WEST SUSSEX COUNTY COUNCIL CONSULTATION

TO:	Arun District Council FAO: A Wood
FROM:	WSCC - Highways Authority
DATE:	25 November 2020
LOCATION:	18 Old Point Bognor Regis PO22 7RY
SUBJECT:	M/83/20/PL Demolition of Existing Dwelling house and Replacement with new Dwelling House - Resubmission of previously approved M/57/20/PL.
DATE OF SITE VISIT:	n/a
RECOMMENDATION:	Advice
S106 CONTRIBUTION TOTAL:	n/a

PROPOSED GROUND FLOOR
SITE PLAN IN CONTEXT, FIRST
FLOOR & ROOF PLANS
1:200

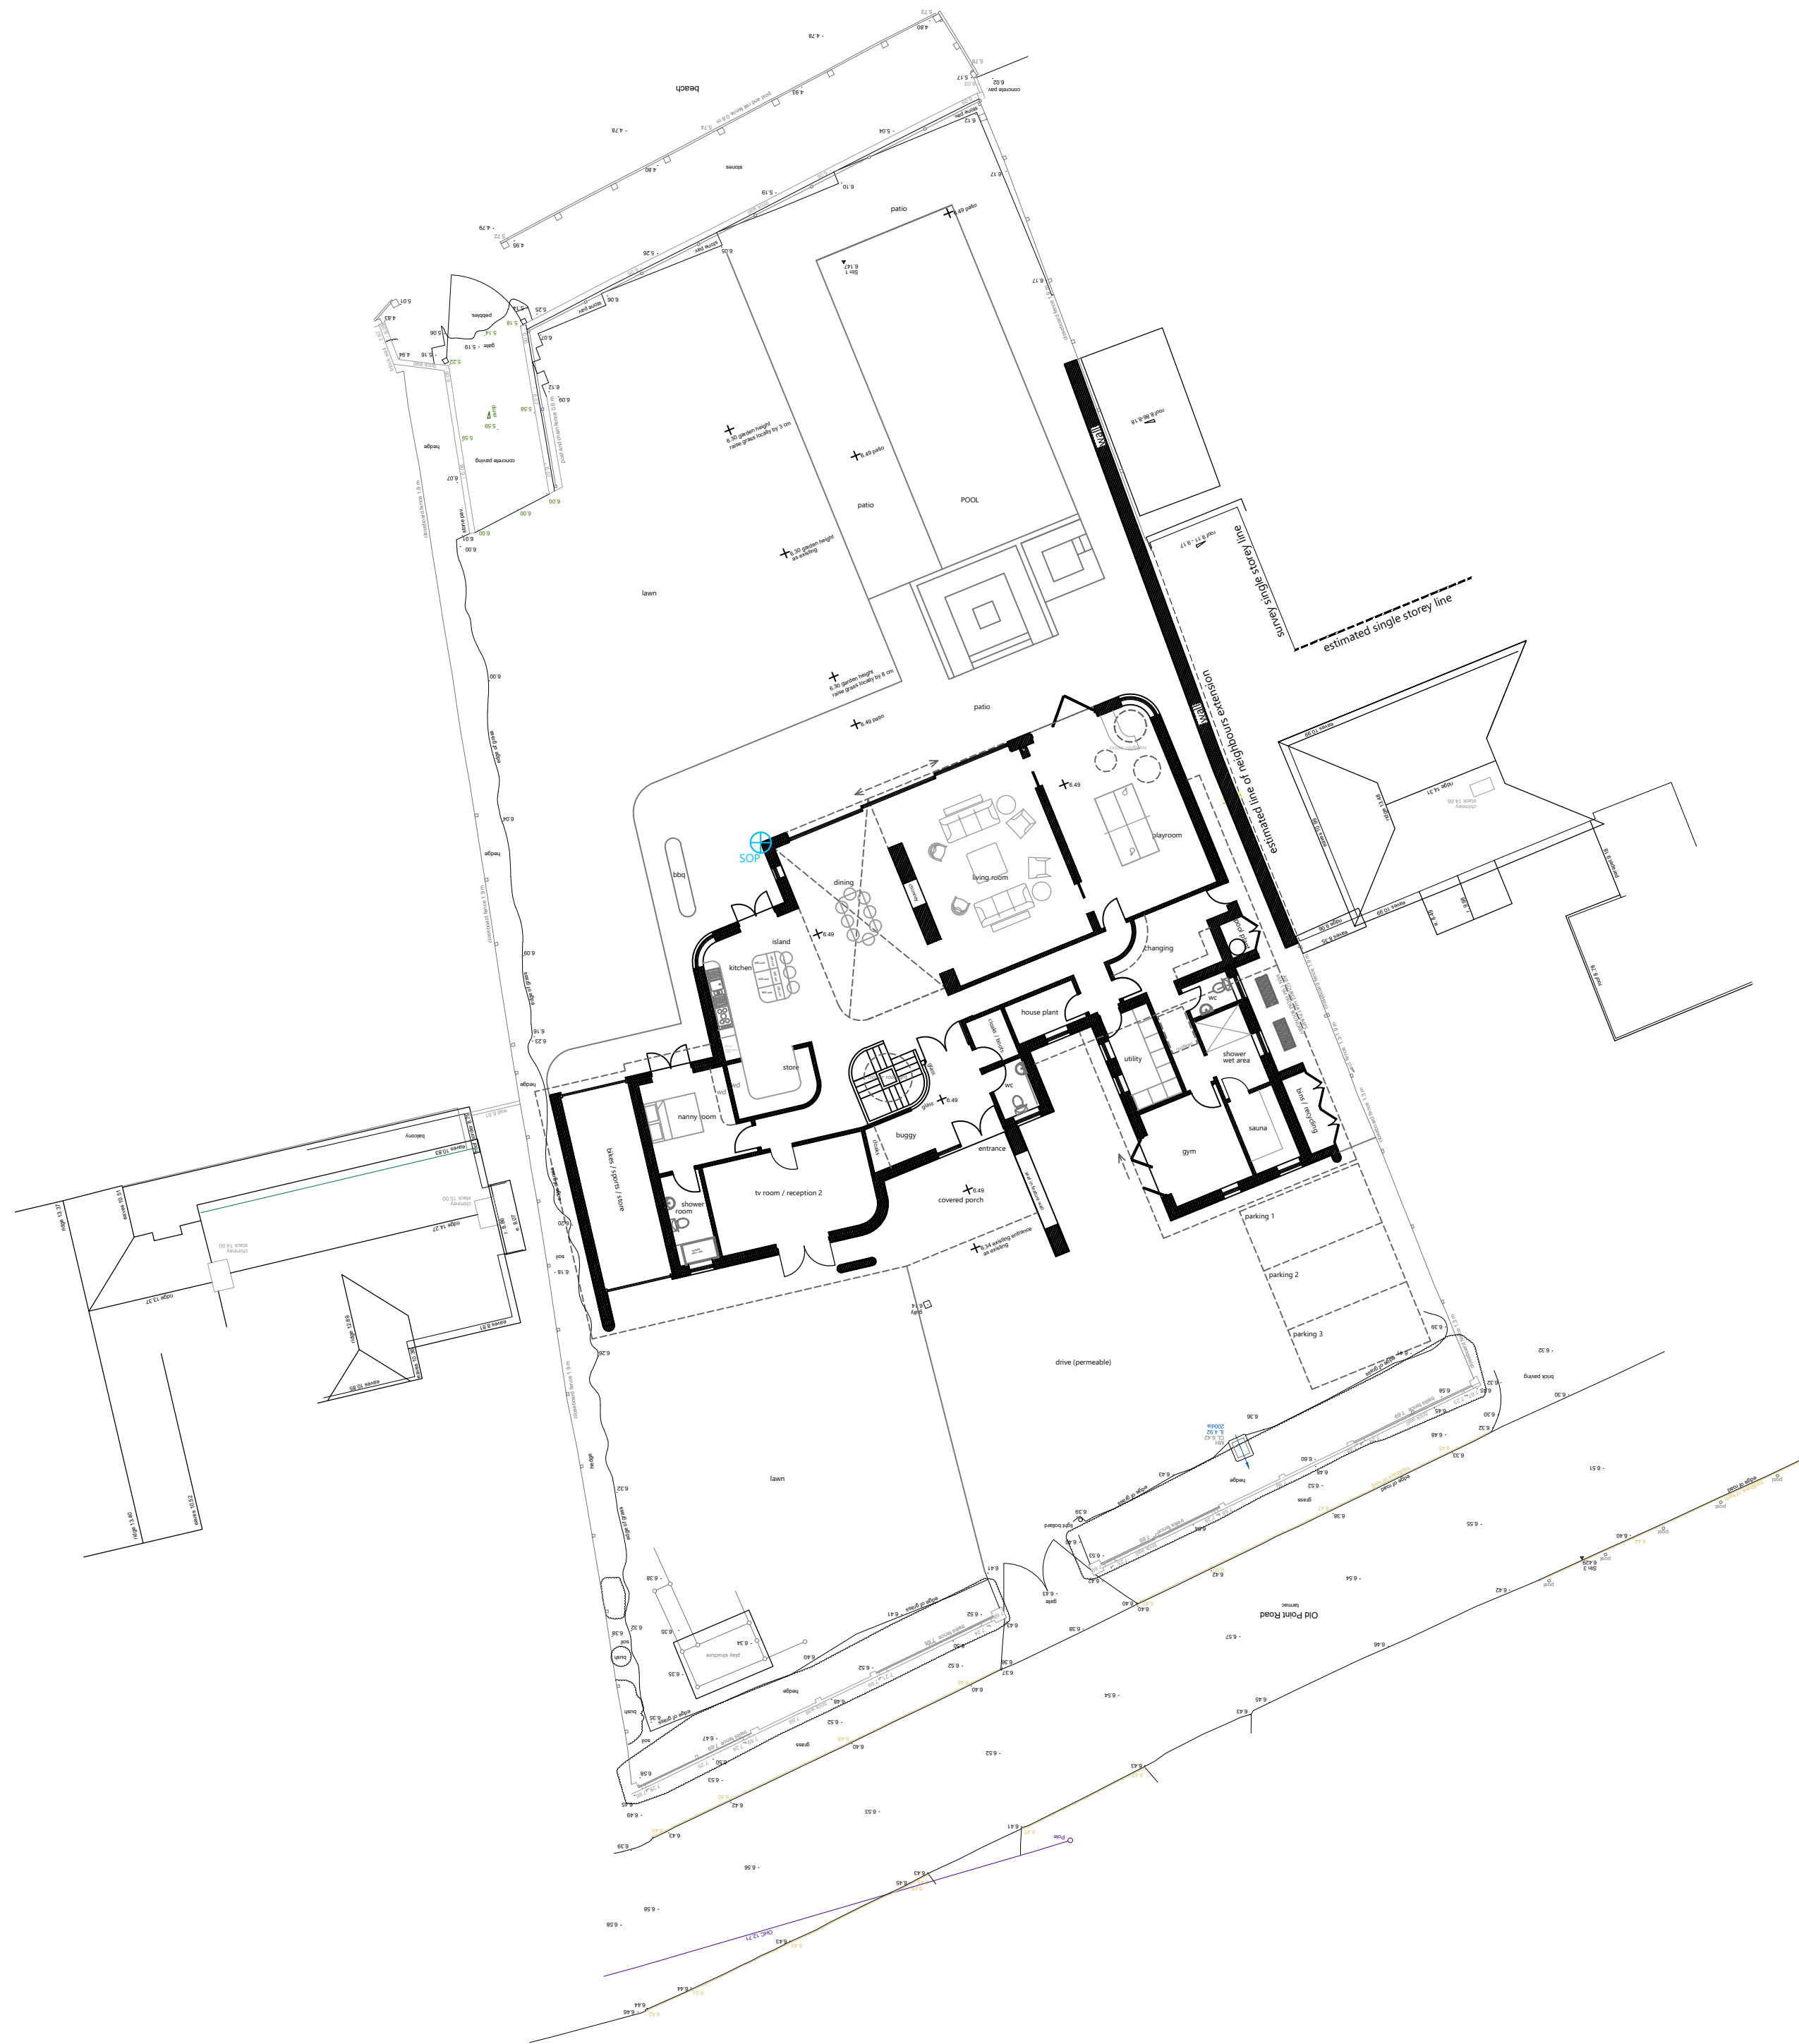
The provided plans indicate that three parking spaces will be provided on the site frontage. The WSCC parking demand calculator would anticipate that three parking spaces would be sufficient for a four bedroom dwelling in this location. Given the proposed dwelling on this site will comprise 6-7 bedrooms, it would not be unreasonable expect that additional parking would be required. However, there appears to be sufficient space on site for additional vehicles to park and turn on site. The LHA would not raise any highway safety concerns to the proposed parking provision as it is not expected that any overspill parking from this proposal would occur on the public highway in this location.

The proposed plans indicate that cycle storage will be provided for the proposed dwelling. In the interests of sustainability and as result of the Government's 'Road to Zero' strategy for at least 50% of new car sales to be ultra-low emission by 2030, electric vehicle (EV) charging points should be provided for all new homes. The applicant is advised that for dwellings with an off-street parking provision, 100% of parking spaces should be provided with active EV parking spaces in accordance with the Arun Parking Standards (adopted January 2020).

No part of the development shall be first occupied until the car parking has been constructed in accordance with the approved site plan. These spaces shall thereafter be retained at all times for their designated purpose.

No part of the development shall be first occupied until covered and secure cycle parking spaces have been provided in accordance with the approved plans.

No part of the development shall be first occupied until the electric vehicle charging space(s) have been provided in accordance with plans and details to be submitted to and approved by the Local Planning Authority.
